CITY OF ALBUQUERQUE

Re: New Addition/ Storage Building
336 Woodward Ave. SE
30-Day Temporary Certificate of Occupancy
Transportation Development Final Inspection
Architect's Stamp dated 06-27-23 (M14-D037)
Certification dated 02-24-2025

2 HC Sign Detail
Scale: 3/4" = 1'-0"

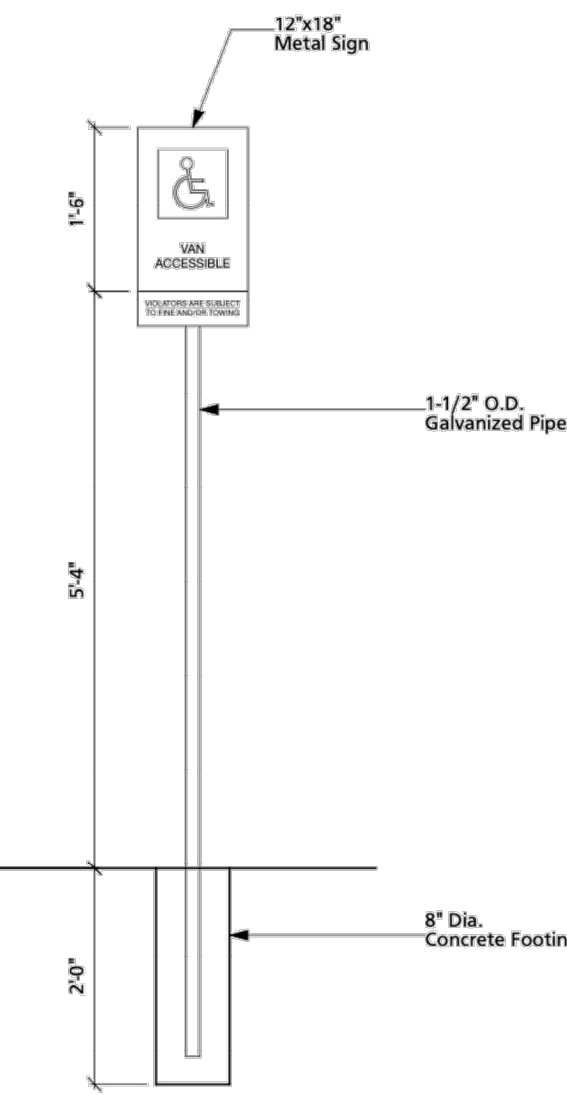
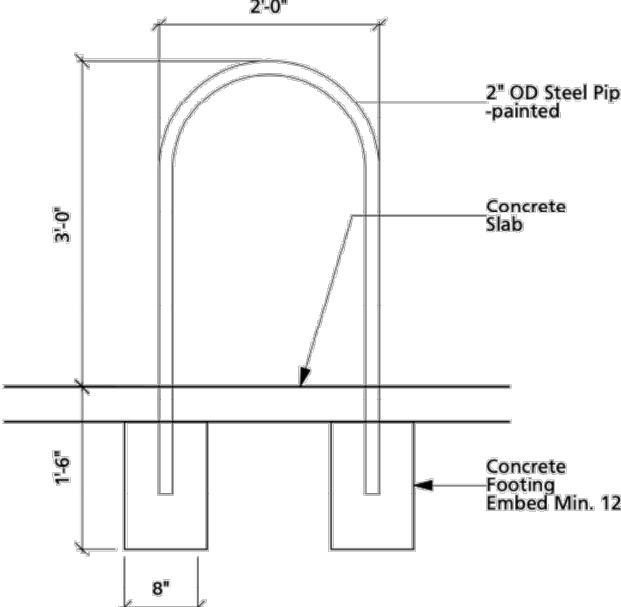
- Provide Certification letter using the standard language. See attached.
- The ADA accessible spaces must include an access aisle. Van accessible aisles should be 8ft wide;
- The ADA accessible parking sign must have the required language per 66-7-352.4C NMSA 1978 **"Violators Are Subject to a Fine and/or Towing."** Please call out detail and location of signs.
- The ADA access aisles shall have the words **"NO PARKING"** in capital letters, each of which shall be at least one foot high and at least two inches wide, placed at the rear of the parking space so as to be close to where an adjacent vehicle's rear tire would be placed. (66-1-4.1.B NMSA 1978)
